1 No new dwelling & detached hydrotherapy pool house along with associated external works & creation of 1 No additional vehicular entrance.

Ferringham House 58 Ferringham Lane Ferring

Thank you for your internet comments made on 23rd April 2020 which has been recorded as **'no objection'** with the comments as follows:

DRAWING TITLE
Proposed Elevations
PLANNING ISSUE

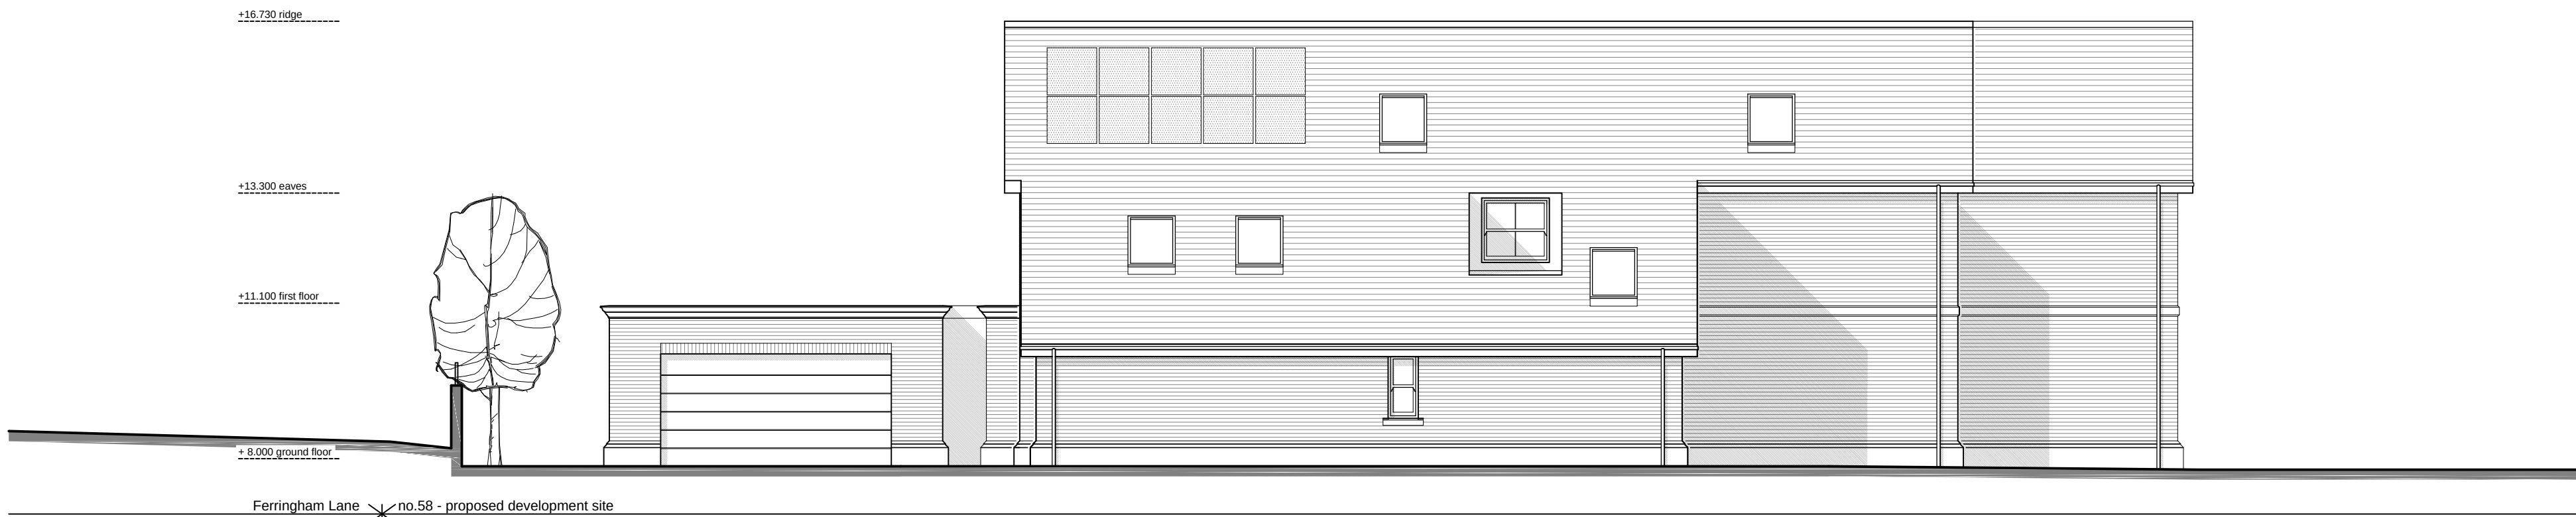
Ferring Parish Council requests the Planning Officer to pay particular attention to the overlooking of the adjacent property from the rear first floor windows and to ensure that any perimeter walls/fencing do not impede adequate highway and egress visibility on the narrow bends fronting the site.
